**Re: Landers Industrial Center Lot 1-B-3, Building 4 – 2220 Unser Blvd. NW
Erosion and Sediment Control Plan
Engineer's Stamp Date 2/6/2023 (H10E006A7)**

Based upon the information provided in your submittal received 2/16/2023, the above-referenced ESC Plan cannot be approved for Building Permit until the following comments are addressed.

SHEET NO:
CG-101

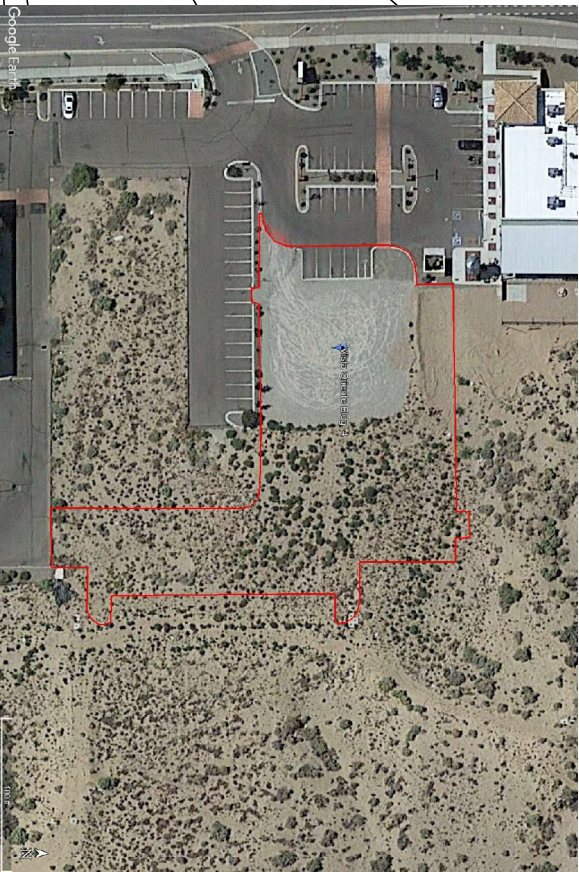
2. The legend includes a line type for the "Property Boundary /Limit of Disturbance" but the line isn't at the correct location of the property boundary. If the boundary and limits of disturbance are at two different locations then you will need to use two different line types. Show the lot lines accurately.
